Our ref: HA/2017/119791/01-L01
Your ref: LU/287/17/PL
Date: 10 October 2017

DEMOLITION OF EXISTING BUILDINGS, CHANGE OF USE & ERECTION OF 1 NO. BUILDING INCORPORATE OFFICE (B1) AT GROUND FLOOR & 8 NO. DWELLINGS AT FIRST FLOOR LEVEL.

47 PIER ROAD, LITTLEHAMPTON, WEST SUSSEX, BN17 5LW.

drawing Proposed rear elevation

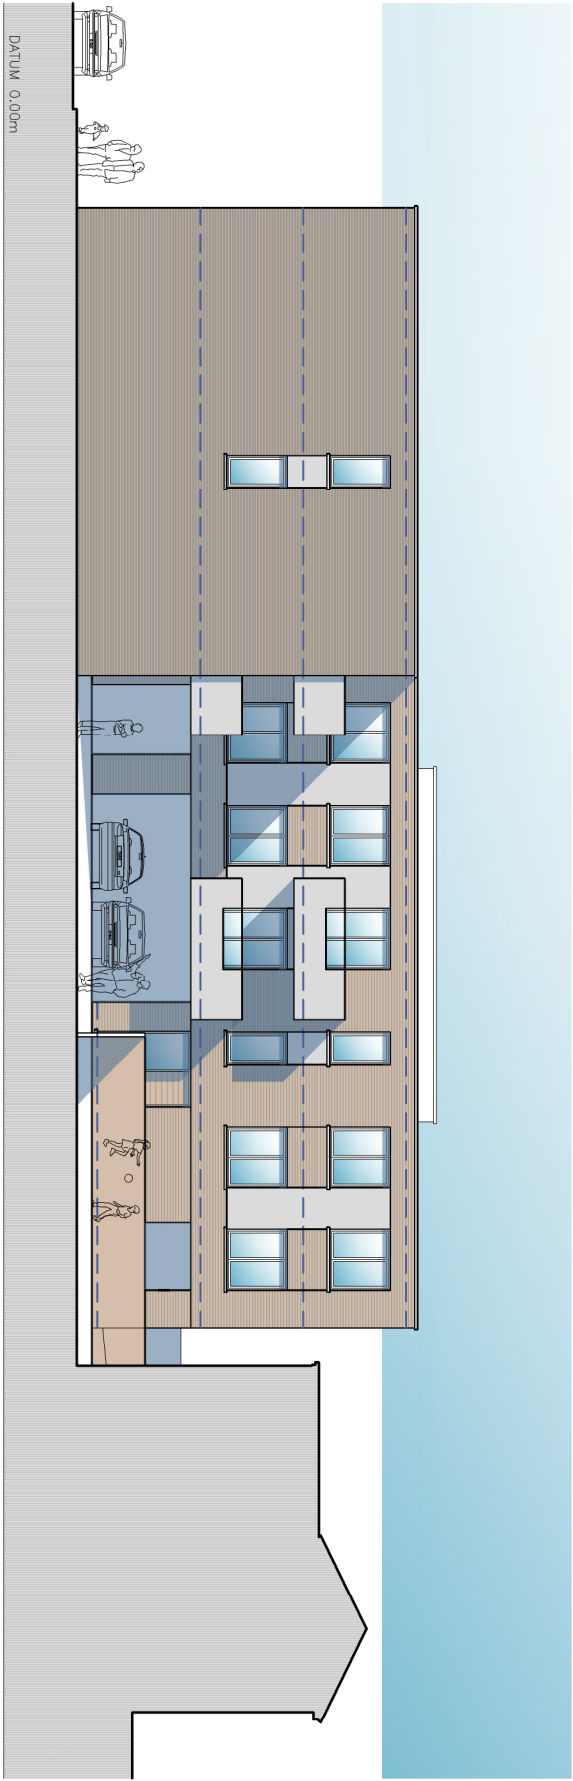
In particular the Flood Risk Assessment (FRA) and associated plans and elevations did

not provide any levels for the finished floor levels of the proposed development. In particular a finished floor level for the first floor of the building, where the habitable rooms have been proposed. Therefore it cannot be determined whether or not this is above the undefended 1 in 200 (0.5%) 2115 flood level of 4.93m AOD.

You can overcome our objection by submitting an FRA which covers the deficiencies highlighted above and demonstrates that the development will not increase risk elsewhere and where possible reduces flood risk overall. If this cannot be achieved we are likely to maintain our objection to the application. Production of an FRA will not in itself result in the removal of an objection.
